From: Charlotte Watkins
Sent: 19 November 2021 01:20
To: Rebekah Morgan
Subject: RE: Bicester Motion 21/01224/OUT - further response re BNG calculations

Dr Charlotte Watkins
Ecology Officer

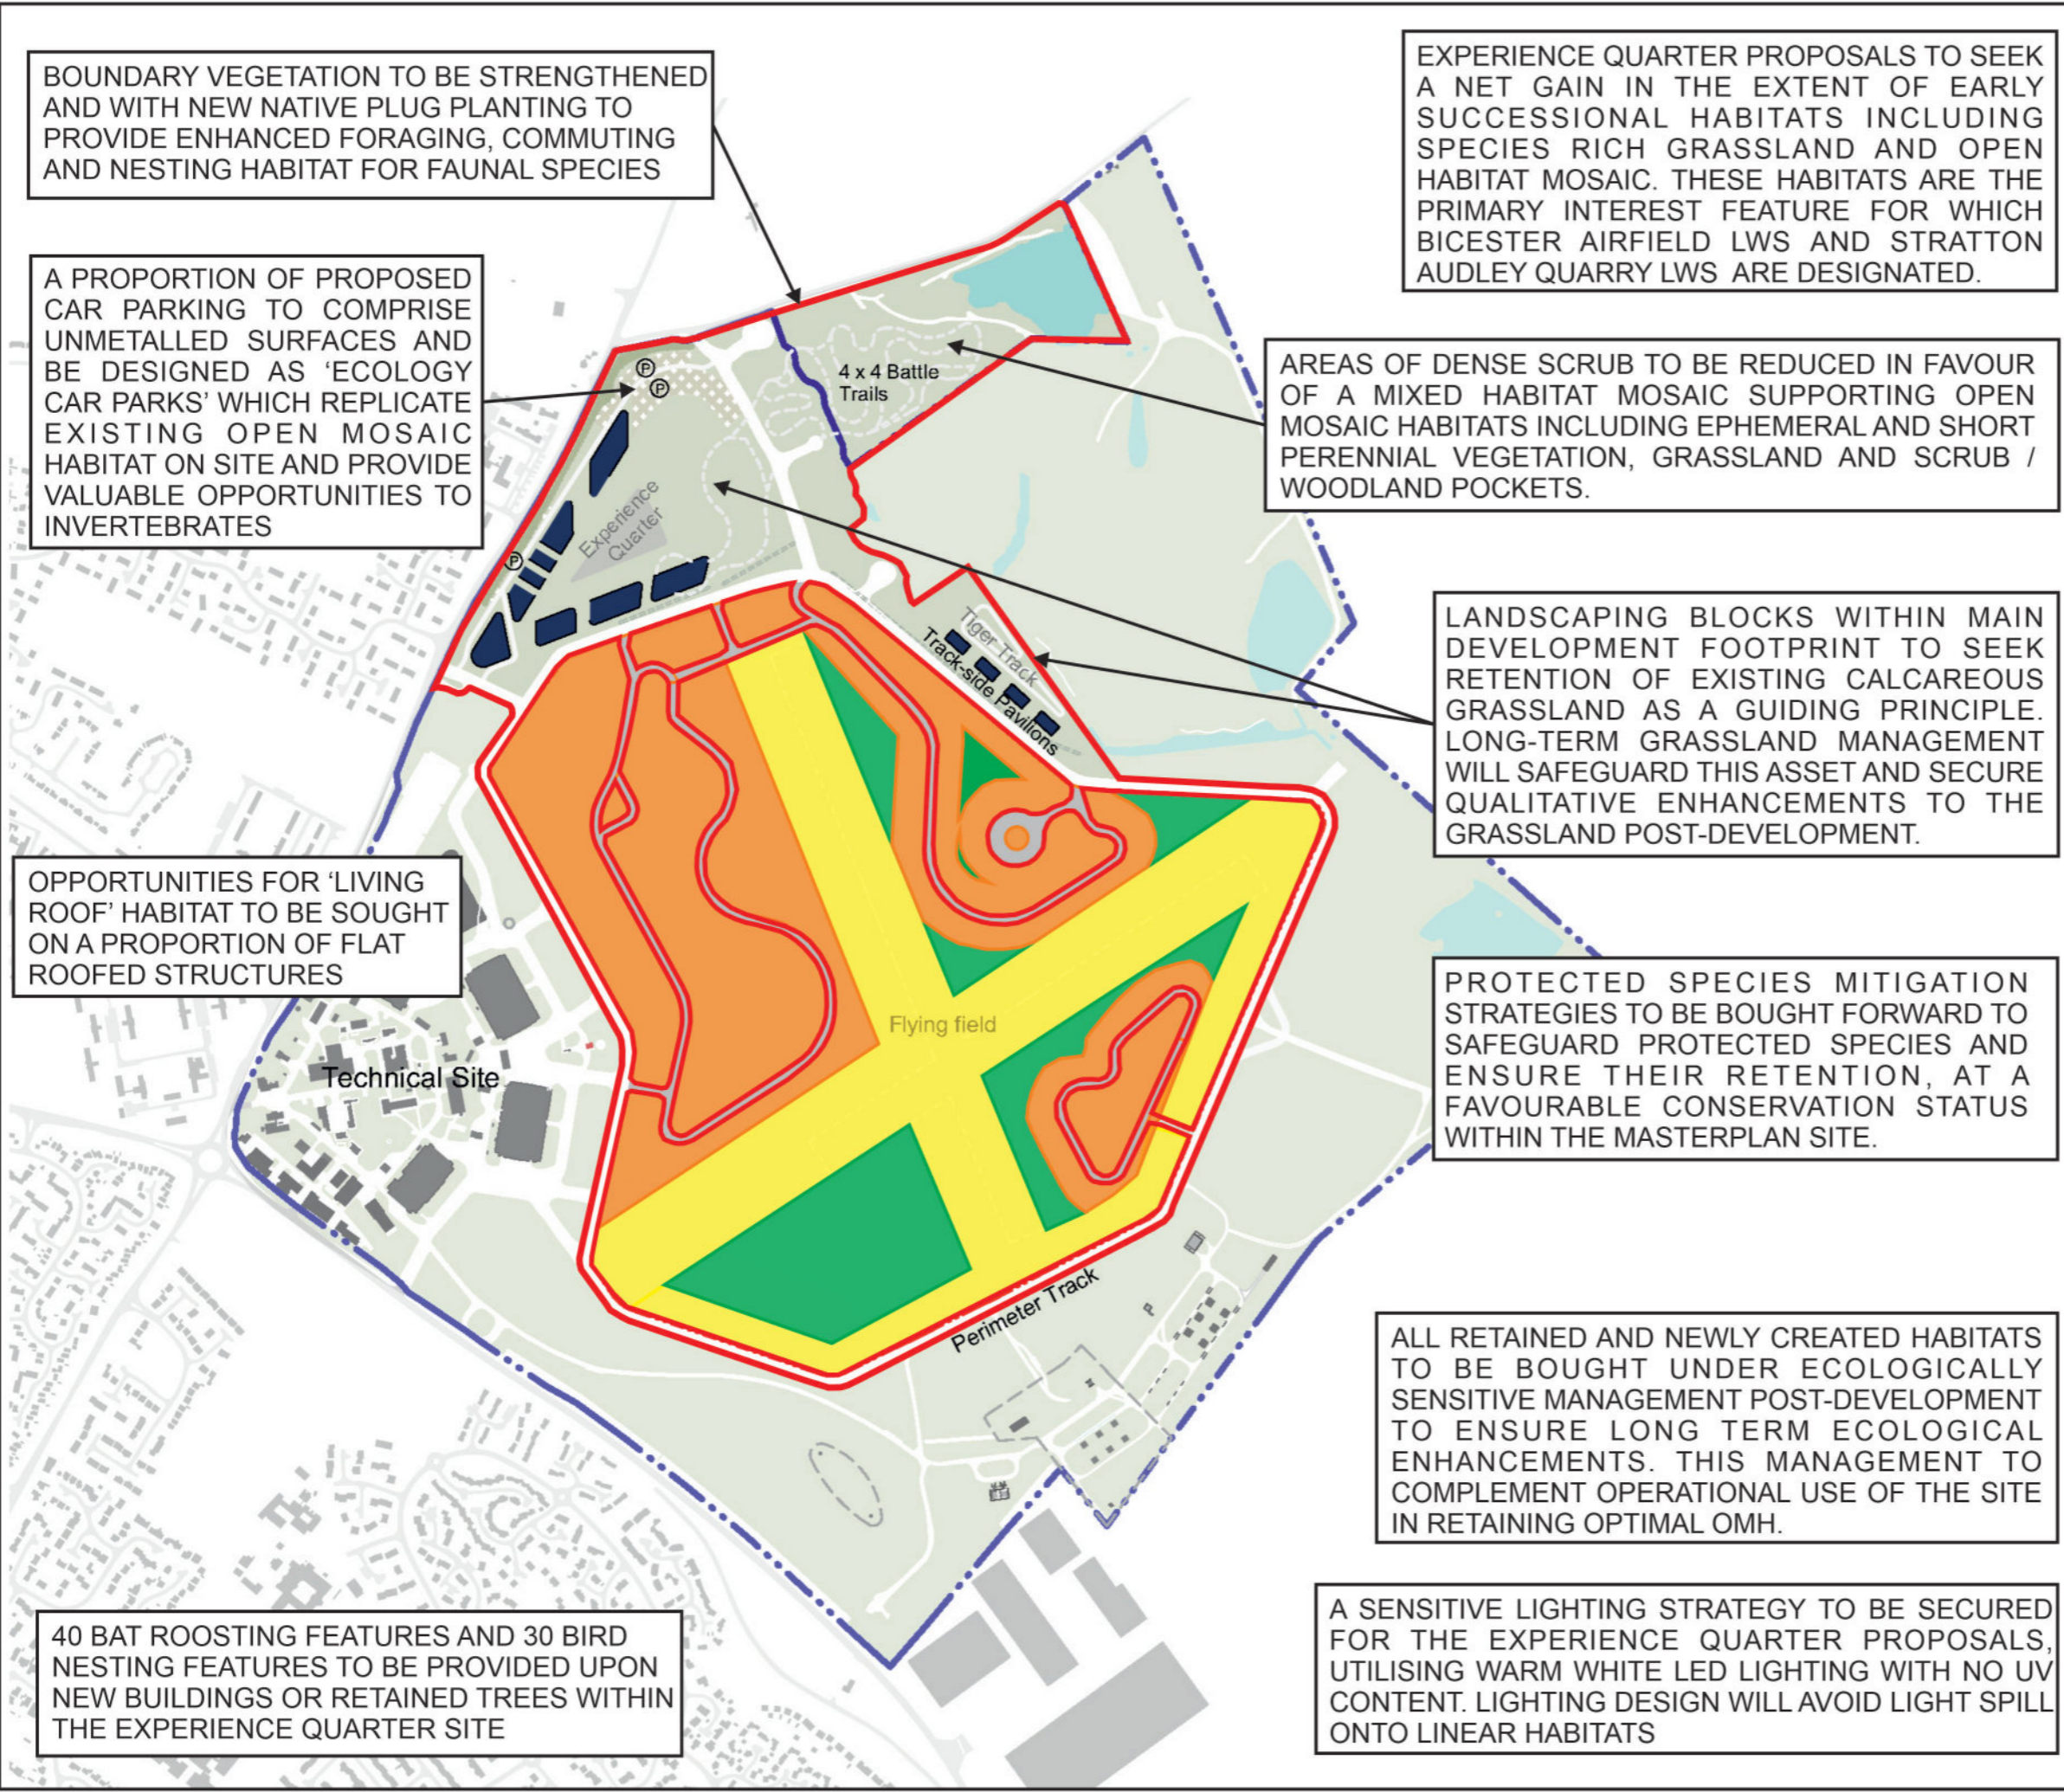
The proposals involve the loss of calcareous grassland and part of the LWS. I am not sure a proper assessment as to why this is unavoidable has been presented with this ecological appraisal. Usually loss of habitat of high distinctiveness, if unavoidable, should be replaced like for like in terms of area and condition (this is highlighted by the error messages within the metric referred to by Bioscan). This is not proposed here. Instead they plan to improve the condition of the current grassland and also allow areas of Open Mosaic Habitat to develop as mitigation and enhancement and to achieve biodiversity unit gains.

I have discussed the use of ecology carparks with Ecology Solutions and can understand that these are of course preferable, ecologically, to hard standing. Whether they will become important habitats for invertebrates in their own right, even with graduated use as proposed, is still something I am unsure of however I understand that they represent only a part of the OMH proposed.
